From: Amanda Scholes on behalf of Planning.Responses
Sent: 26 June 2019 09:23
To: Planning Scanning
Subject: FW: Planning Consultation on: FG/46/19/PL

Engineers comments regarding surface water drainage

2019
Site Address: East Of The Bluebird Cafe South Drive Ferring
BN12 5QU
Grid Reference: 509153 101498
Description of Works: Refurbishment of existing car park. Providing a permeable SuDS ground reinforcement grid paving system. Providing a level allocated car parking spaces.

01 PROPOSED SITE PLAN
Scale: 1:200

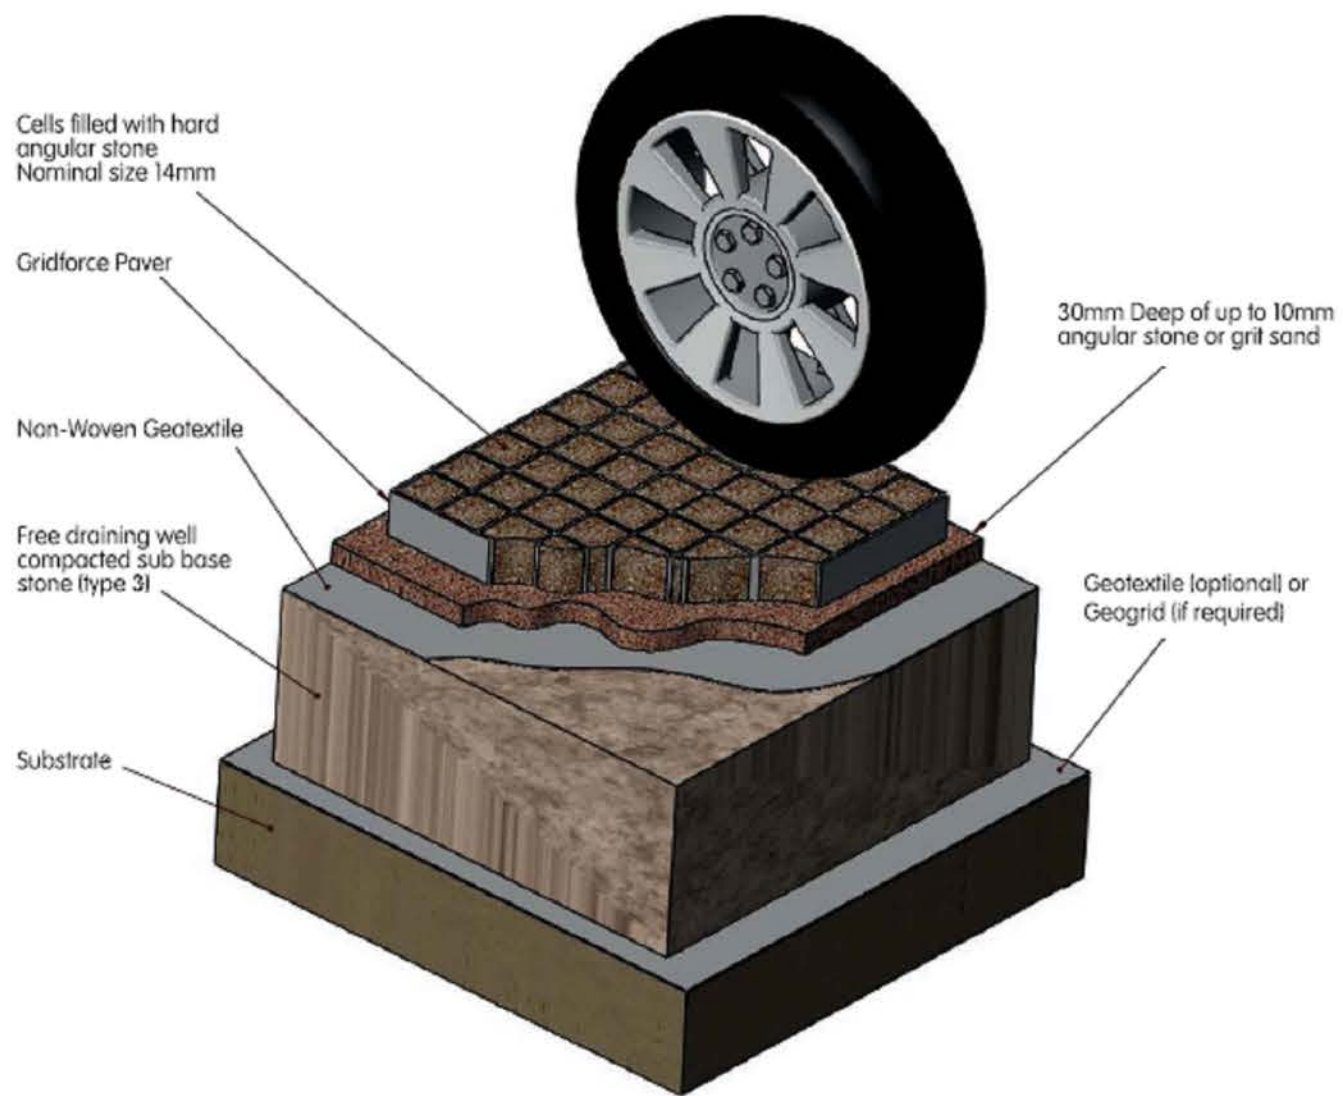
The grid and materials that are proposed to be used to form the parking surface would form a permeable surface. As a result the proposals would not increase runoff, and would as closely as possible reflect what was there previously. We therefore have no conditions to request.
